From: Laura Gibbons
Sent: 27 June 2018 14:45
To: Planning.Responses
Subject: RE: Planning Consultation on R/117/18/DOC

Engineers Comments Relating to Condition 11- surface water drainage

APPLICATION R/117/18/DOC
NO:

Registered: 24-MAY-18
Site Address: Fleur De Lis Station Road Rustington BN16 3BH

Scale: 1:125	Paper Size: A1	Date: JUNE 2017	Drawn By: JH	Checked By: CH
Project No. RRL012	Drawing No. 505	Revision: P4

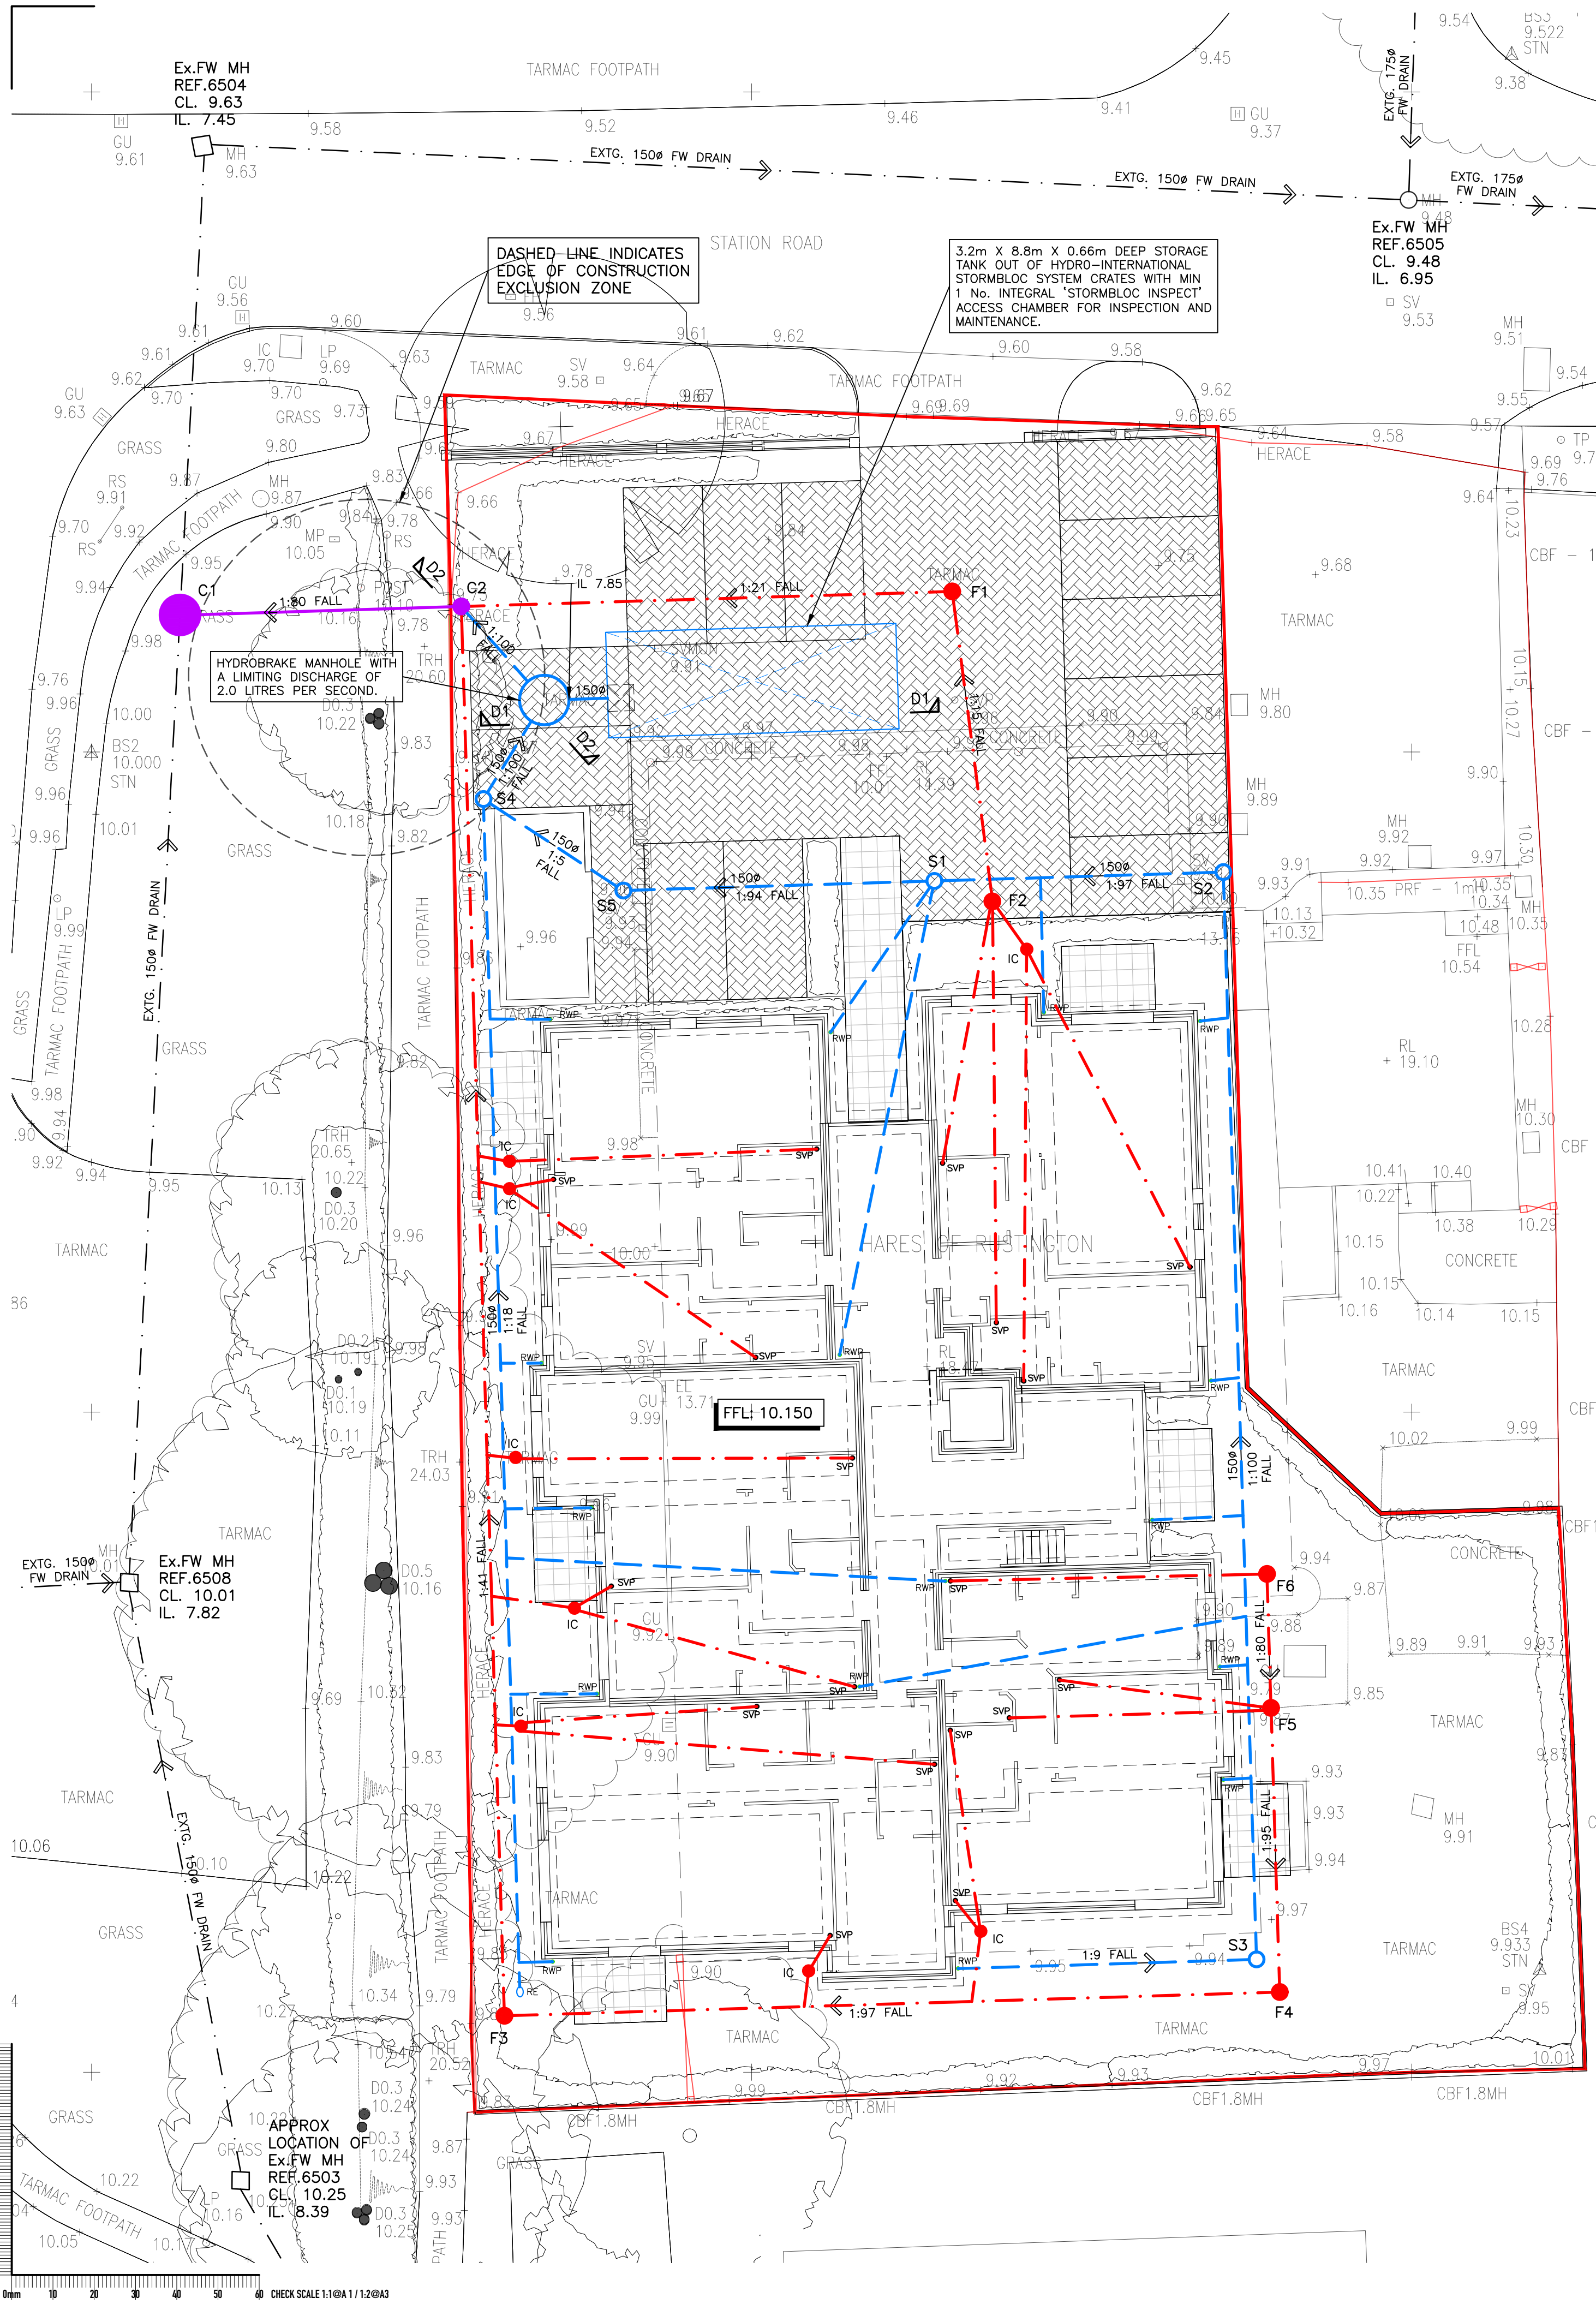
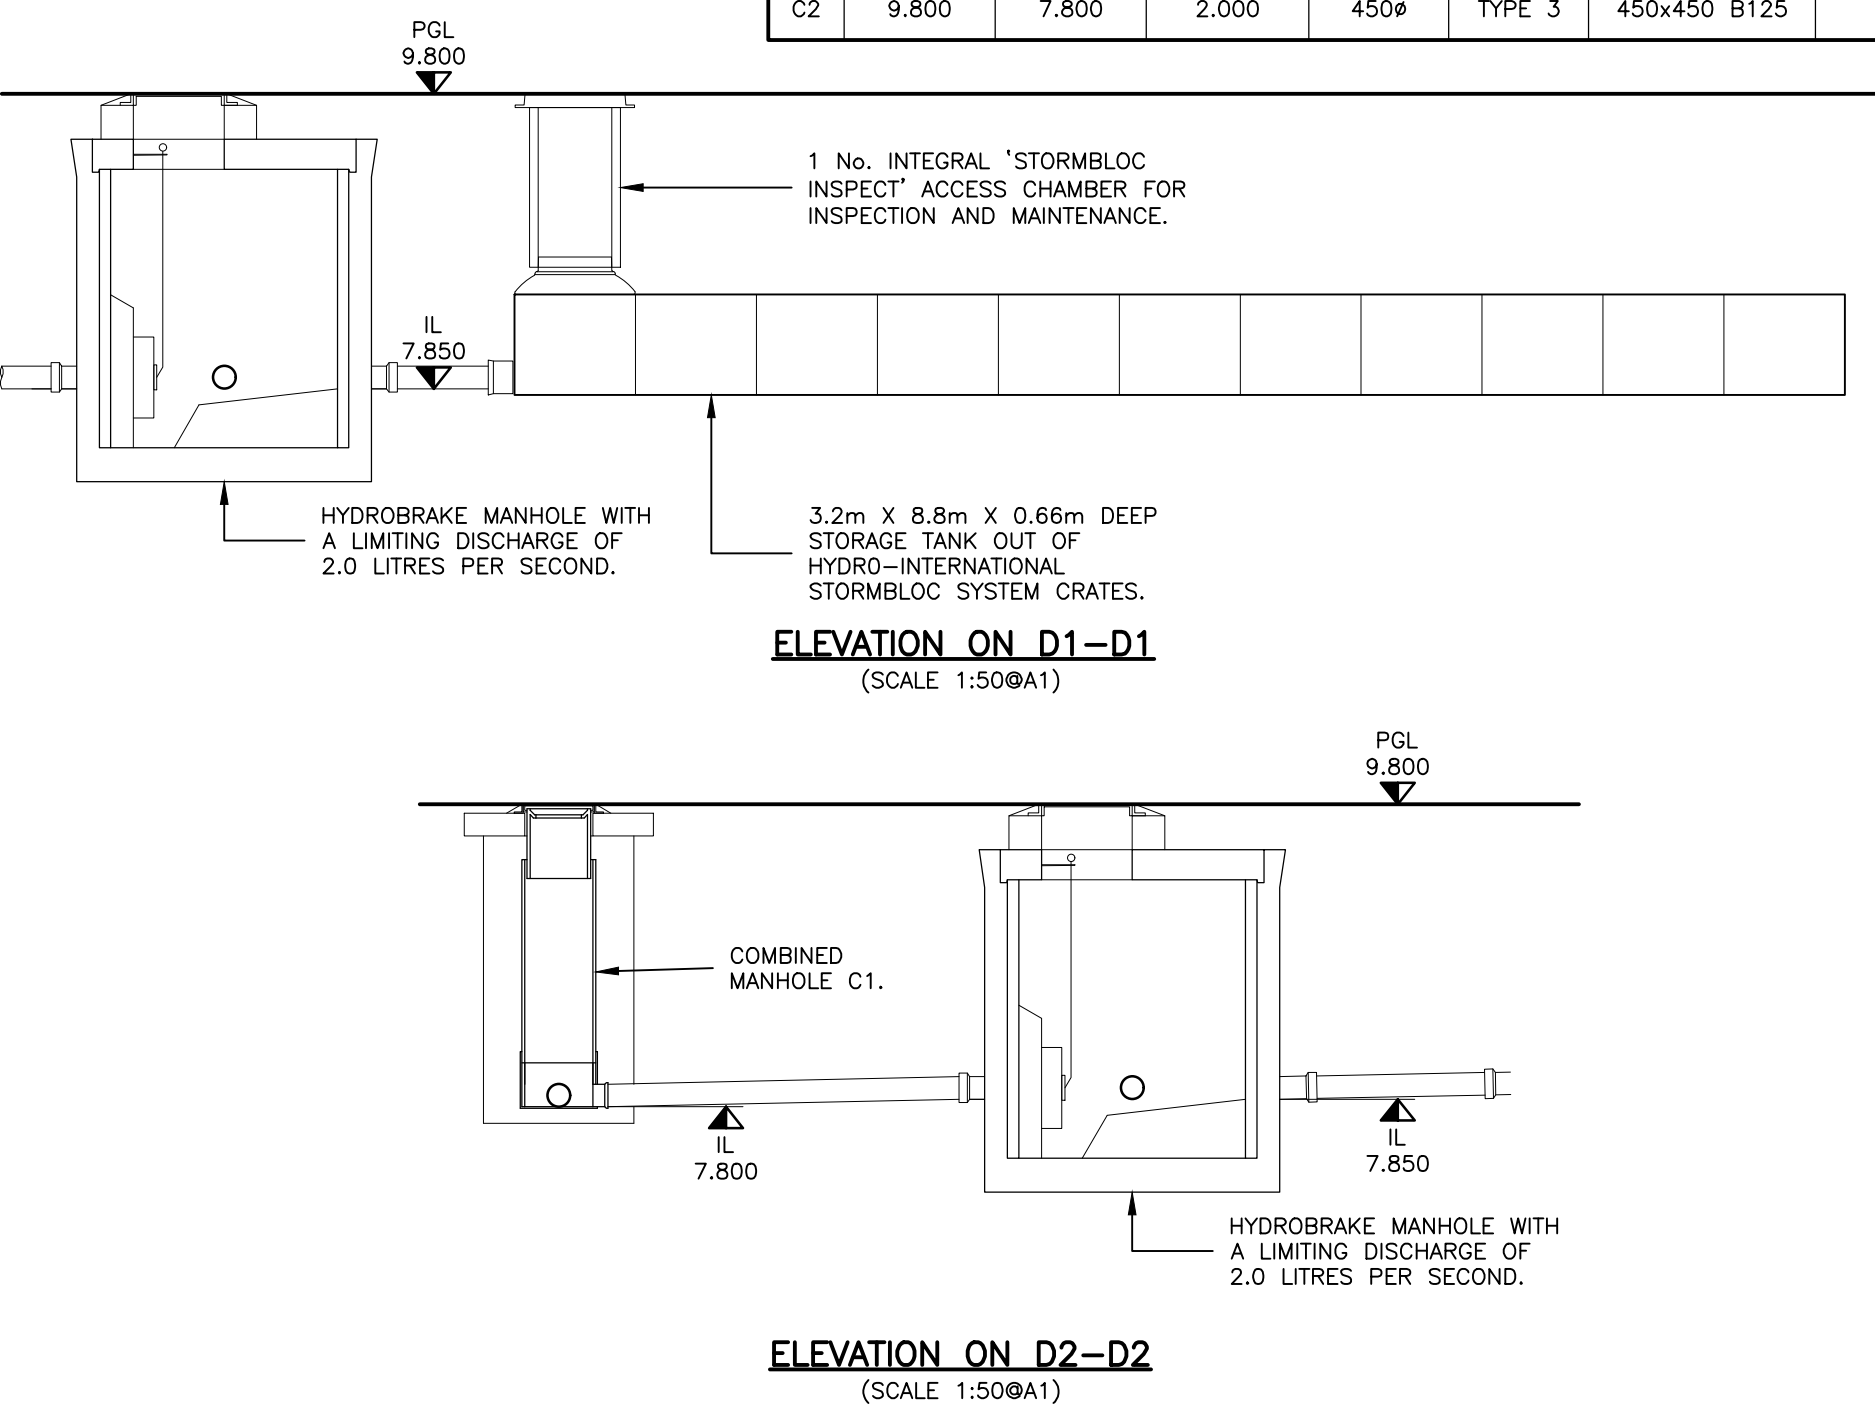
In response to the previous DOC application (R/6618/DOC) on the 19th April, I stated the requirement that the results of winter groundwater monitoring and percolation testing be supplied and that disposal of surface water to foul sewer is the last resort.

Please supply the winter groundwater monitoring data and percolation test results to enable the DOC application to be reviewed.
